From: [REDACTED]
Sent: 21 December 2023 23:13
To: Planning
Subject: Comment on planning application 3/2023/0926

Application number 3/2023/0926

Location address: 2 Water Meadows, Longridge, PR3 3BW

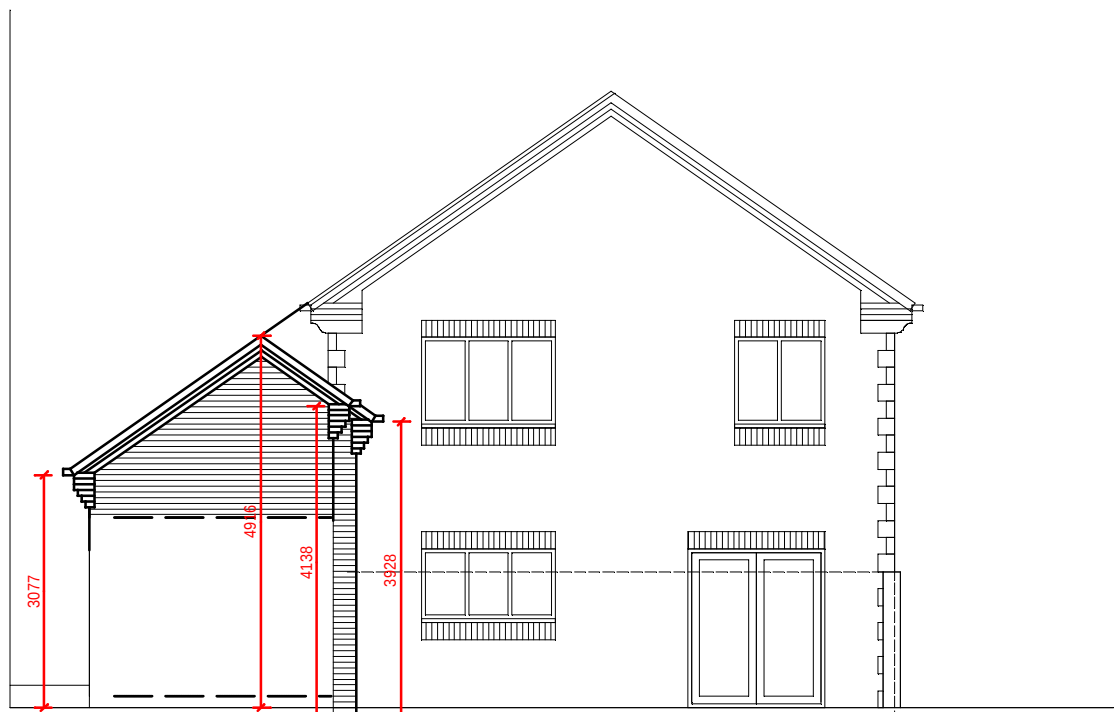
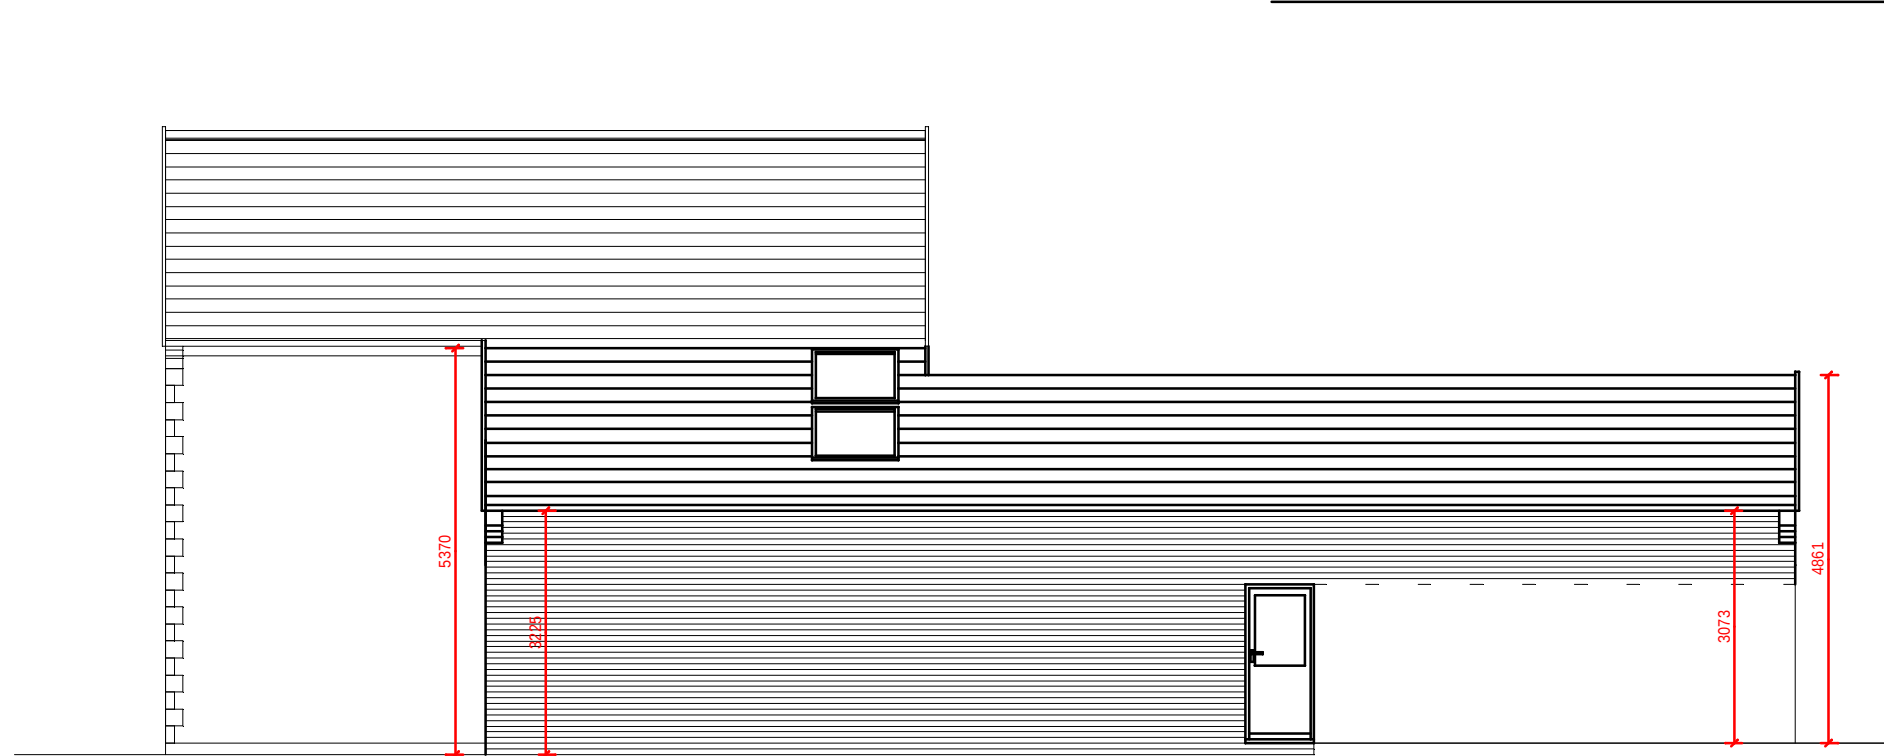
The proposed extension will not be built on to the back of the house but will be formed from the existing garage that sits at the end of the driveway. The garage is [REDACTED] any alteration to the height and width of the building will impact the sunlight [REDACTED] This is because the sun comes round the garage, from the south in the mid-morning and early afternoon [REDACTED] If the extension is built as proposed, [REDACTED]

The scale and position of the proposed extension is vast so that the increased roofline height (a total of 5m) and width of the extension will form a solid block which [REDACTED] We feel this is totally unfair.

The design of the extension with large glass windows facing south is indicative of the fact that the sun comes from this direction for most of the day.

Site Plan - 1:200

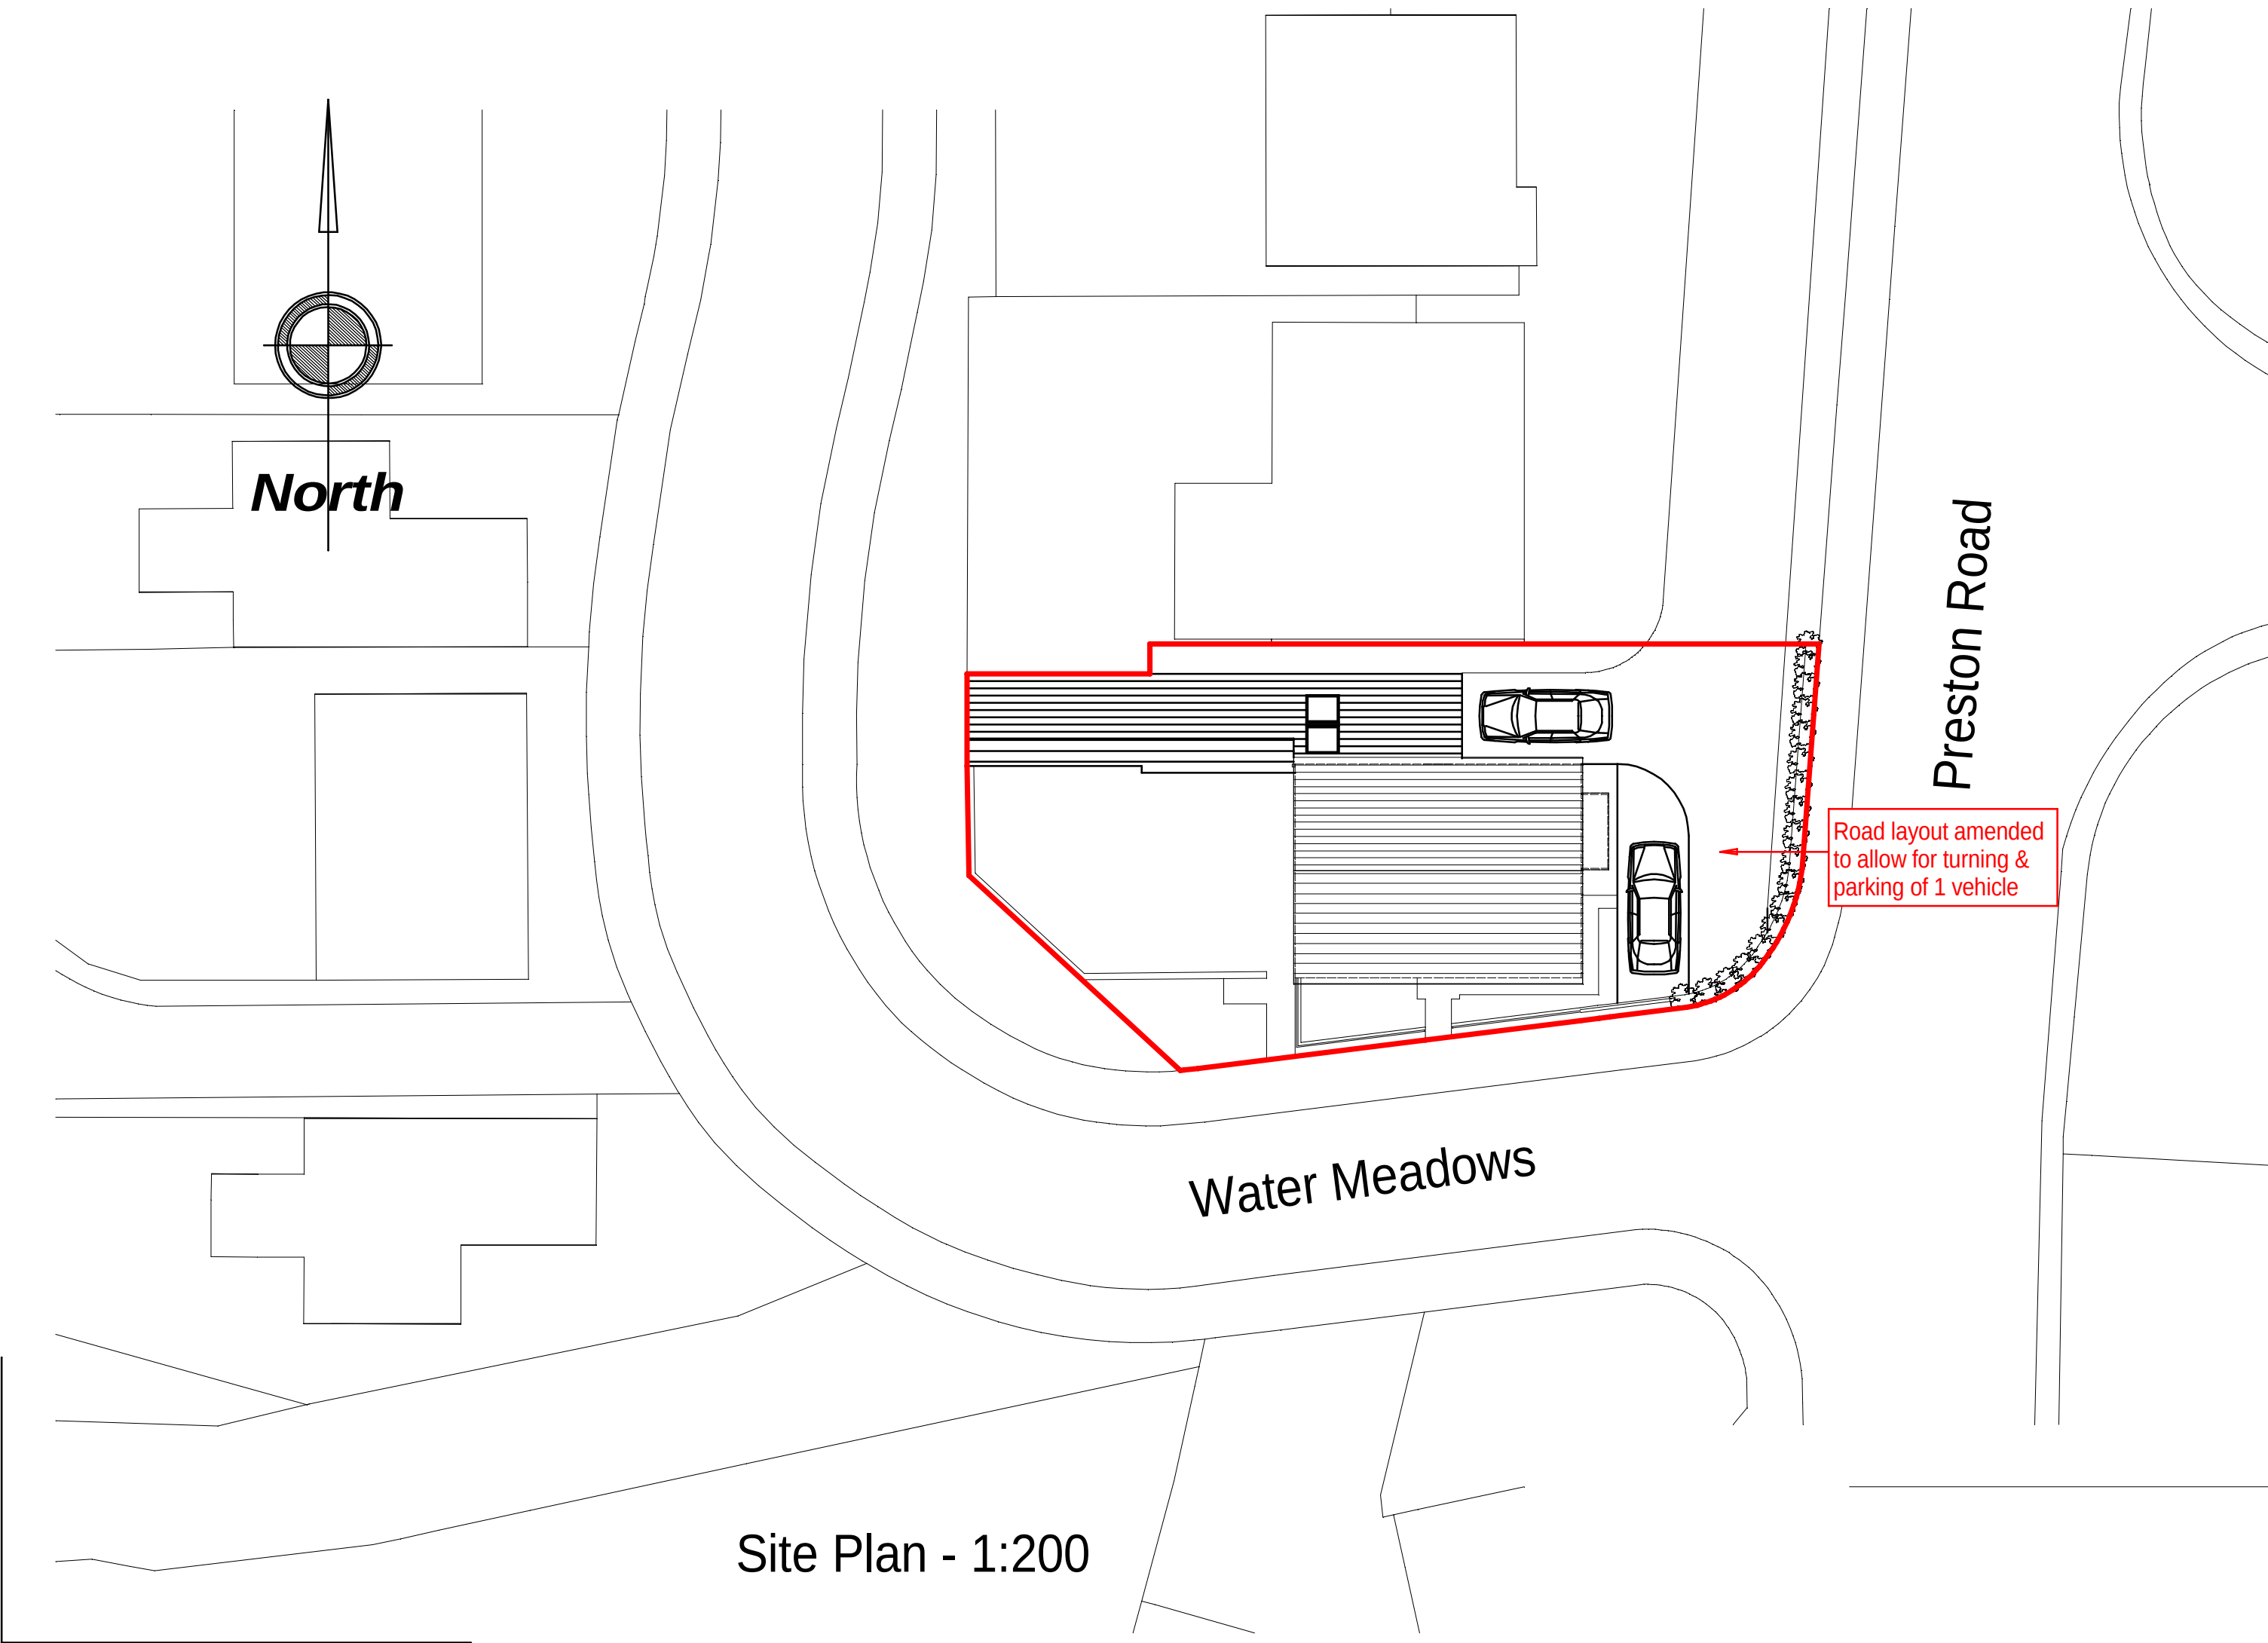
The property sits at the end of a row of 4 houses that have a shared access driveway. Currently, the property has room for at least 2 or 3 cars down the driveway and space in the turning point at the top of the shared access driveway. The proposed extension will reduce the available parking area and could result in visitors to the property

It is also our understanding that the previous planning application made in 2021 was rejected on the basis that the proposed development would result in the loss of off-street parking that would lead to vehicles being displaced to the turning head of the shared access road thus removing the facility required to enable vehicles, including visitors and delivery vehicles, to turn within the site and enter and leave in a forward gear. This would be injurious to the safety of other highway users and contrary to Policies DMG1 and DMG3 of the Ribble Valley Core Strategy.

We do not see anything in the new plans that addresses this adequately.
